**Consultation Response from KC,
Highways Development Management**

2026/91323 4, Wesley Place, Dewsbury, WF13 1HX

Demolition of existing building and erection of extension to existing motorcycle shop with additional parking

Responding Ref: 15-2NW/29

4.7 Parking Arrangements

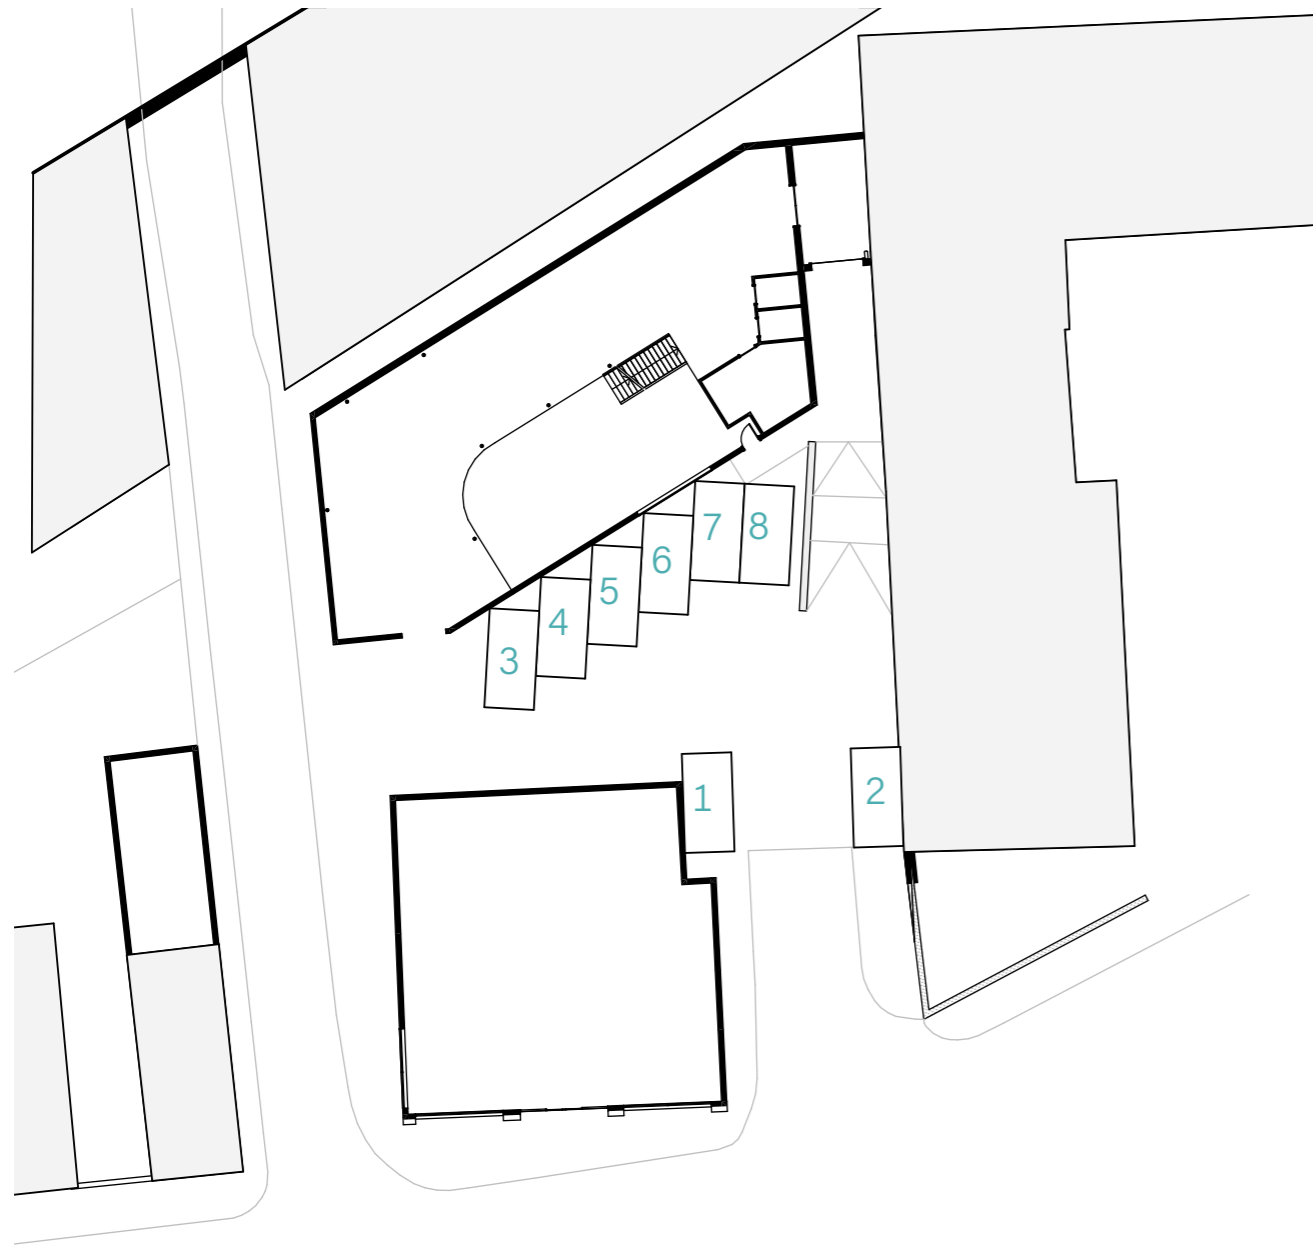
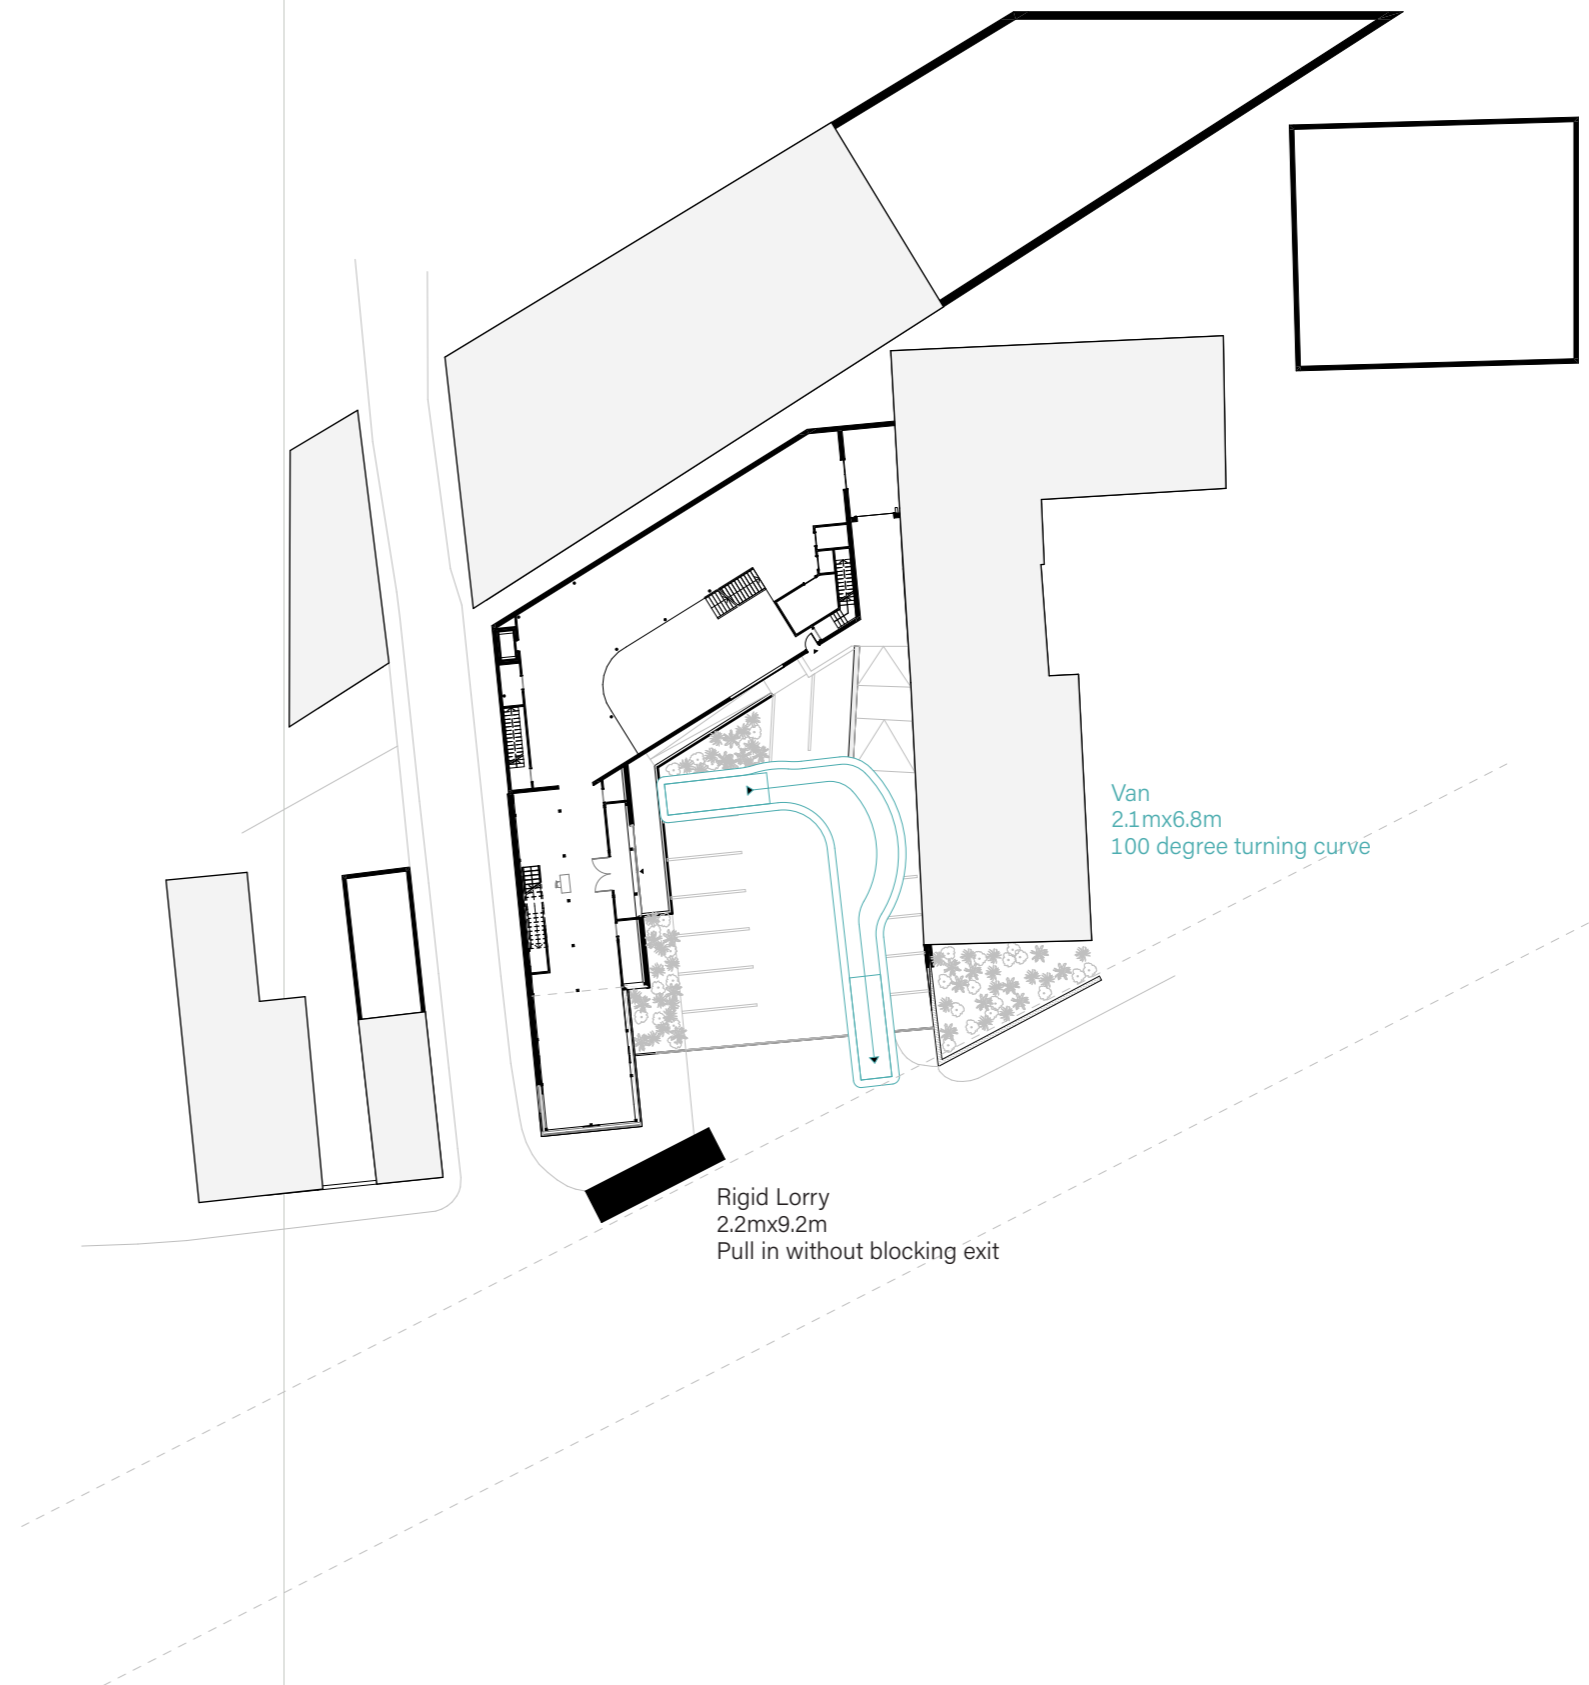
There is to be a single electric vehicle charging point, with two cable enabled spaces which would support policies LP20 and LP24 to encourage sustainable travel and the lowering of emissions. The amount exceeding the typical 10% provision of the net increase in the number of spaces and future proofing to meet an uplift.

The dimensions are acceptable for standard car parking bay sizes and an aisle over 6m to allow for manoeuvring and entry and exit in a forward gear.

The proposal indicates 12 car parking spaces. An increase in four spaces. This amount is expected to be appropriate and offer flexibility to meet policy LP22. Kirklees does not have parking standards and seeks to ensure that parking provision is appropriate to the needs of a development and not reduced below a reasonable level. For those Councils that do have parking criteria, the number of car parking spaces for retail is based on an assessment on the amount of gross floorspace, number of staff as well as level of accessibility and proximity to the town centre. Typically, higher levels of accessibility require operational levels of parking. These circumstances are found at this proposal site. Whilst, it is proposed to have 16 staff FTE's, they are unlikely to be on site all at the same time due to shifts and may not all travel by car. For those that do travel by car, there would be space within the site or elsewhere in the town.
